Recommendation Report

Application No. BE/136/11

Remove garage doors & replace with front door & window with lounge & store room
Rookstone Shripney Road Bognor Regis PO22 9NZ

Block Plan

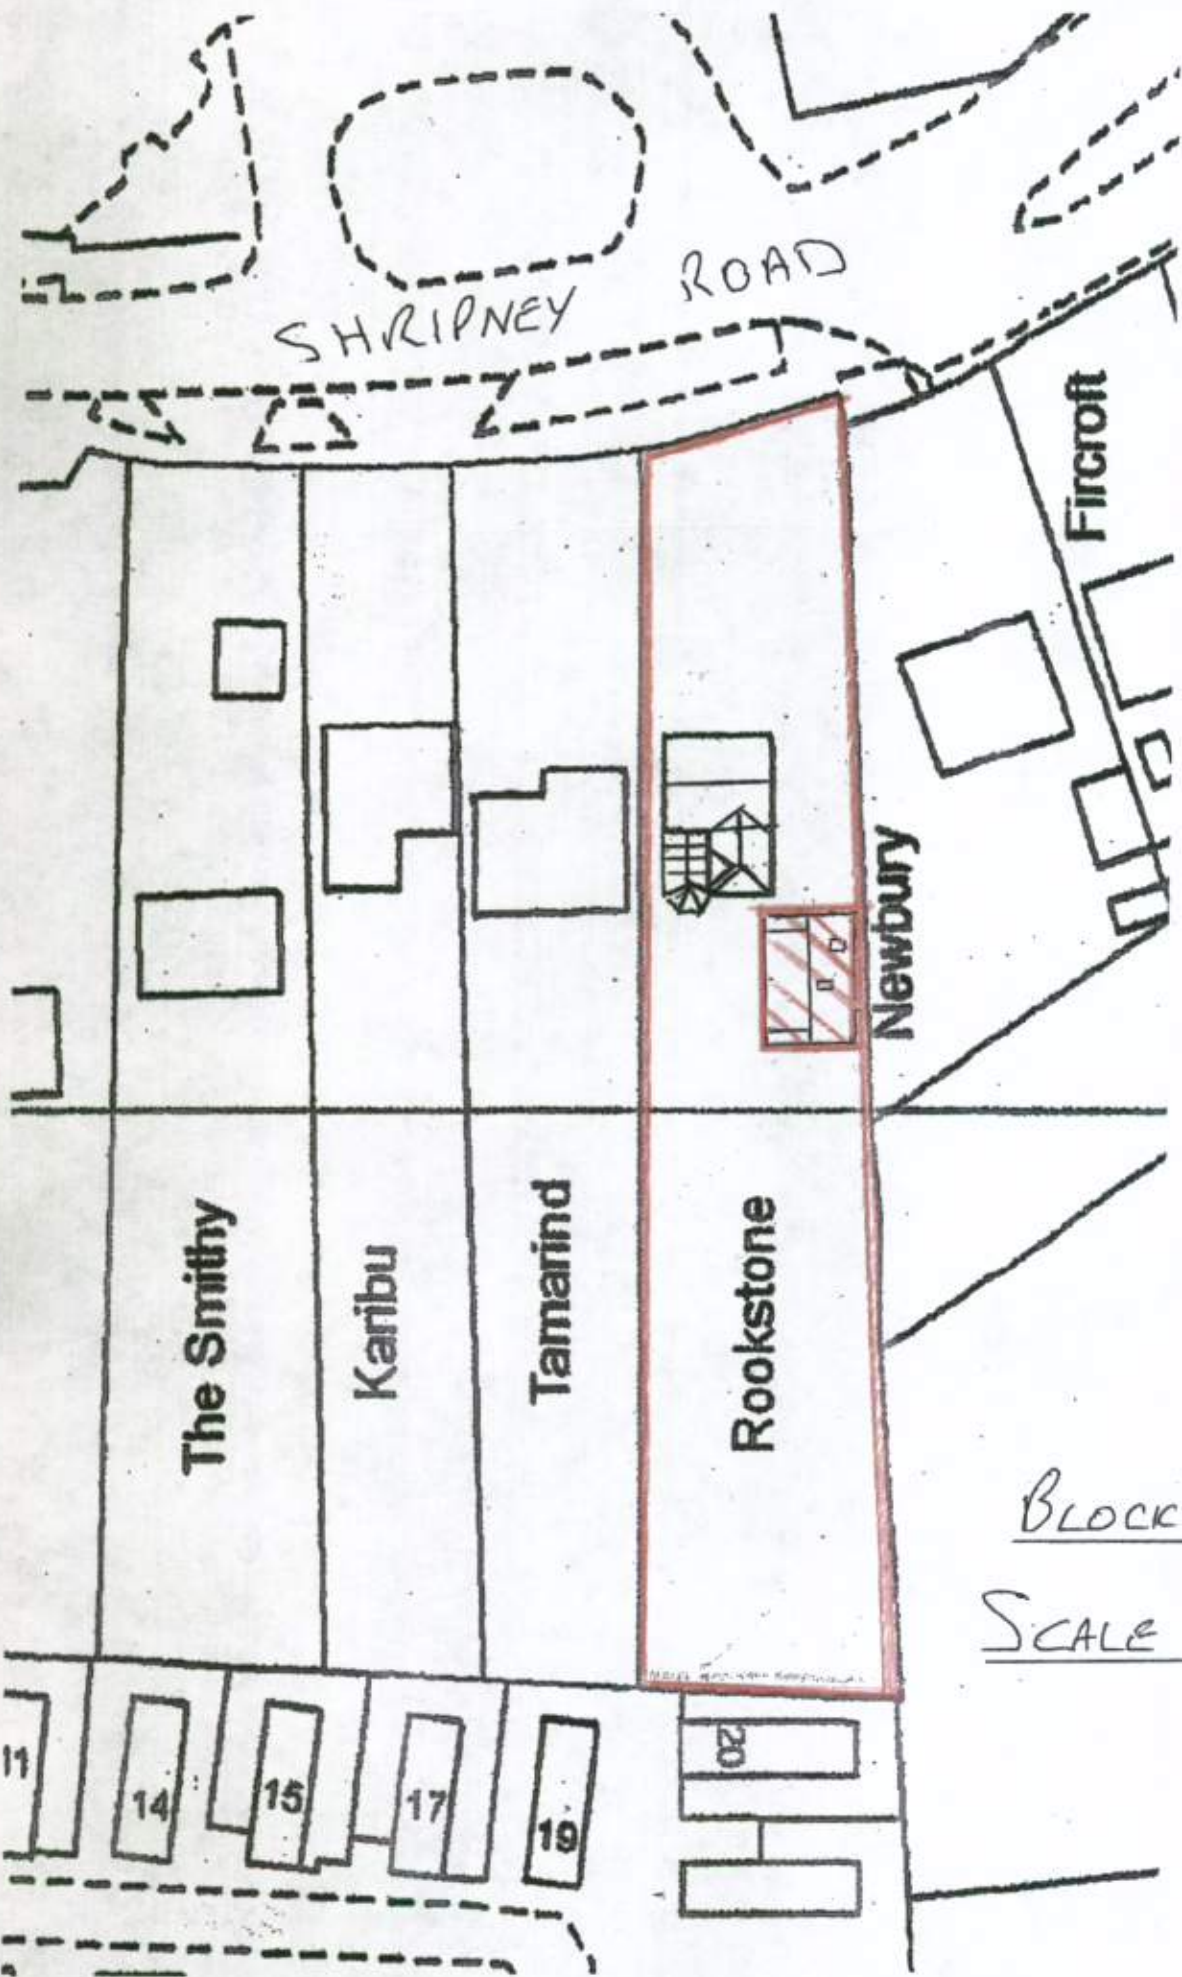
Please amend the enclosed block plans to include a scale

Please submit amended block plans to include a North point & clearly highlighting the position of the proposal.

Proposed East Elevation

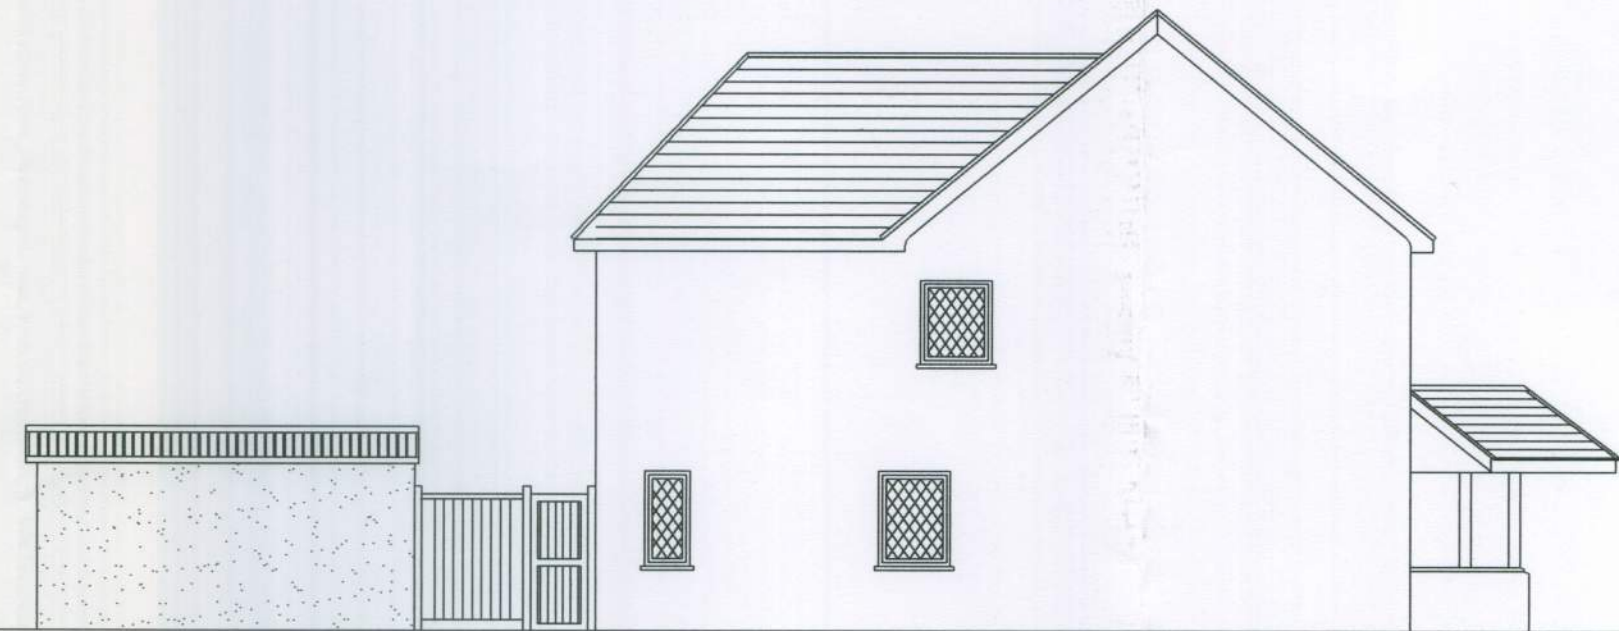
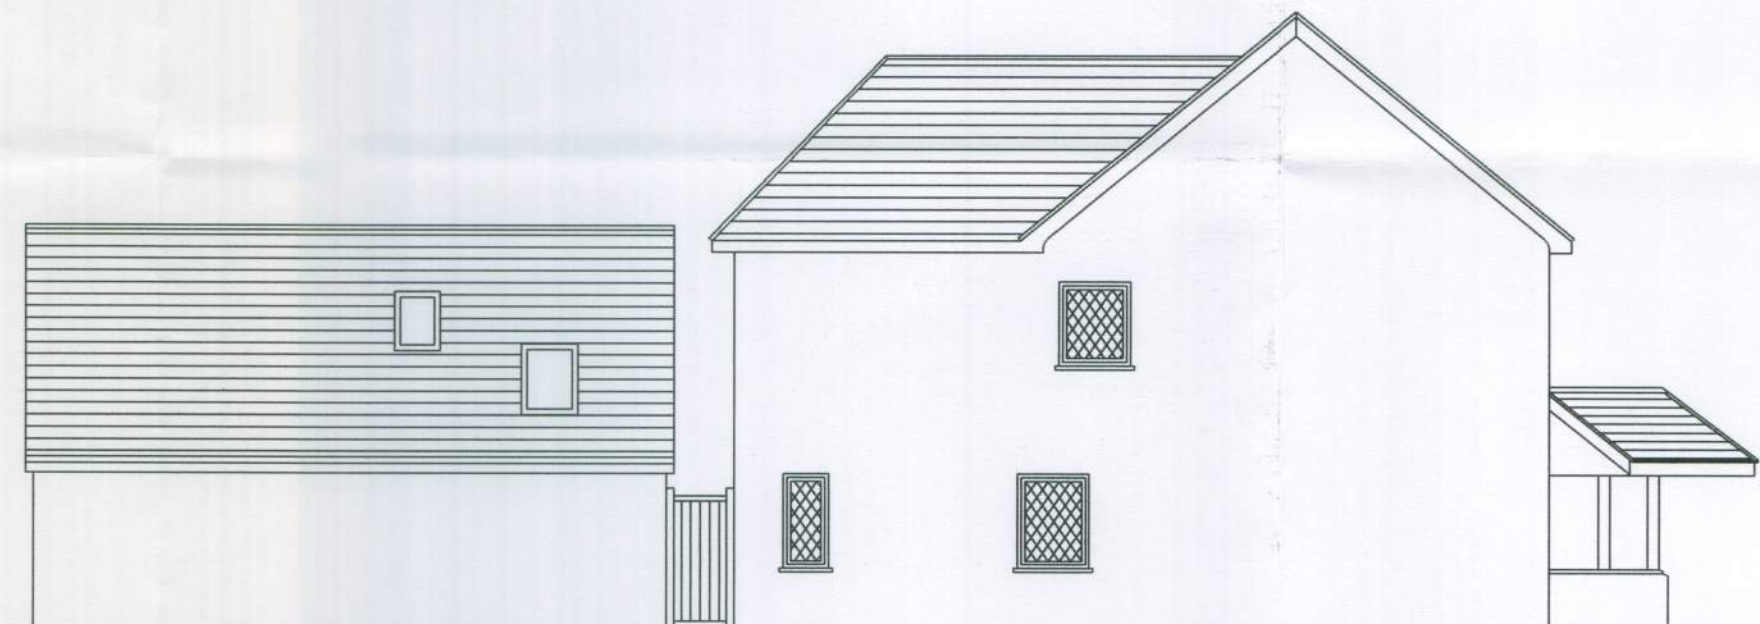
Door + windows "intended" on front elevation

Proposed West Elevation

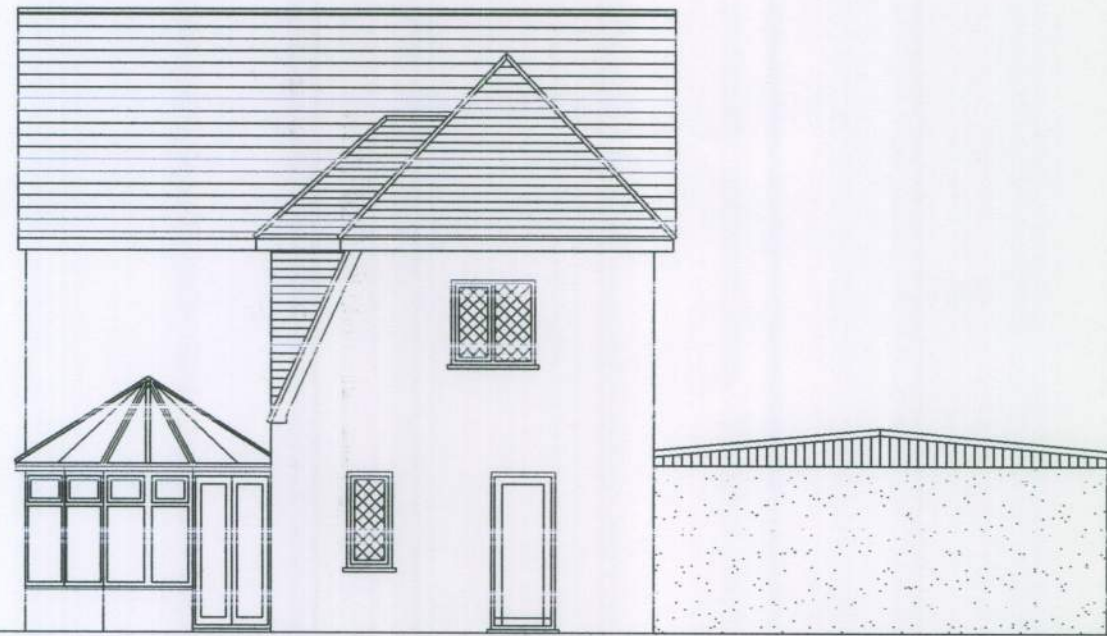
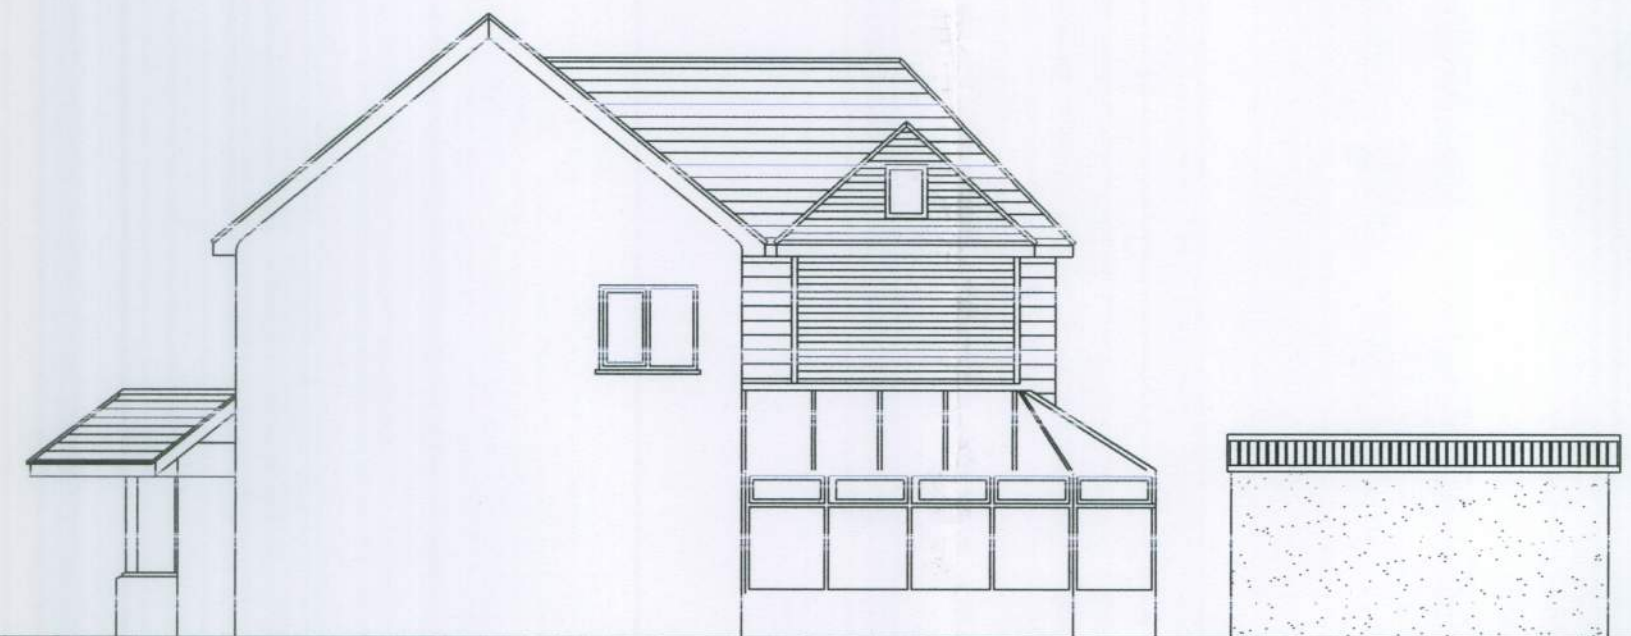
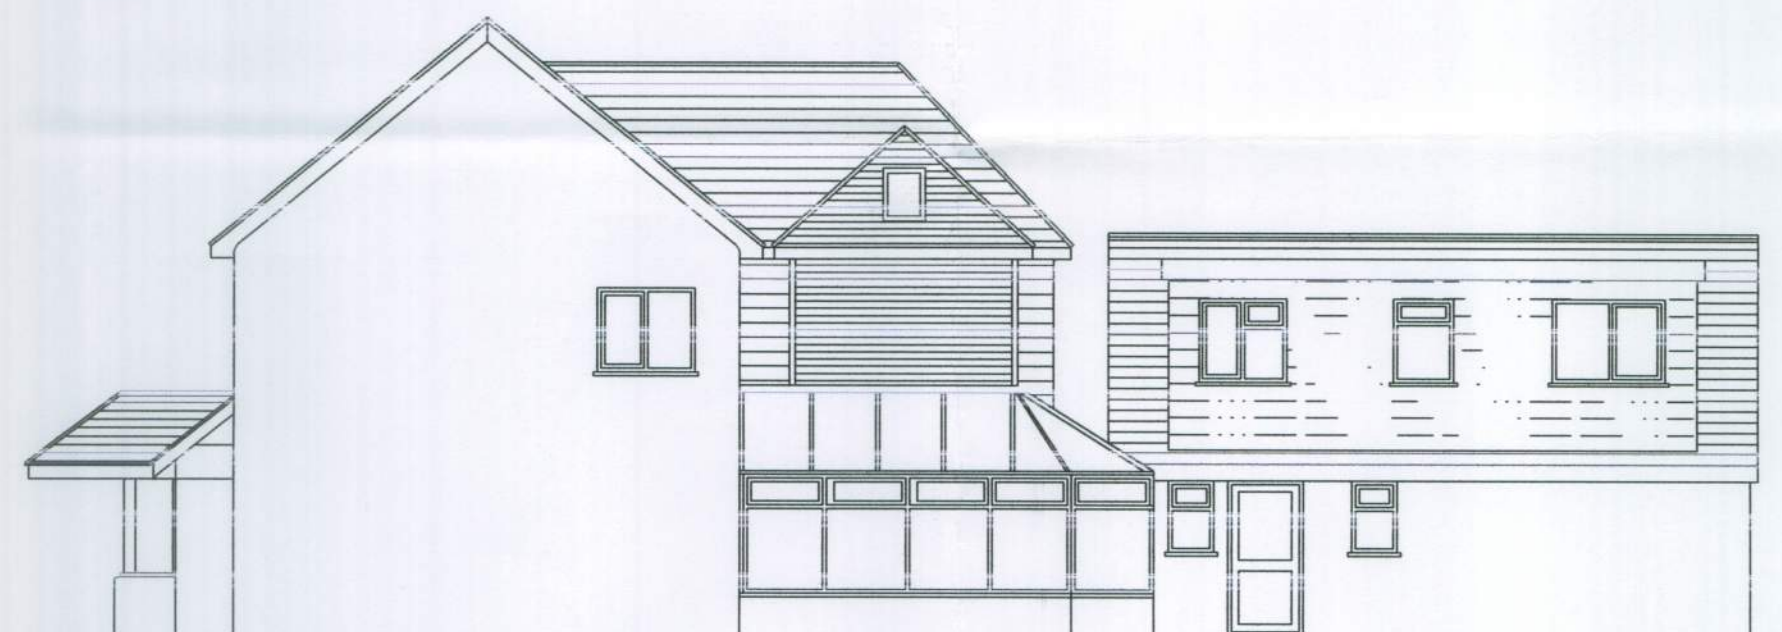
Side roadlights - not in accordance with plans - direct visibility into neighbour's private rear garden + rear conservatory
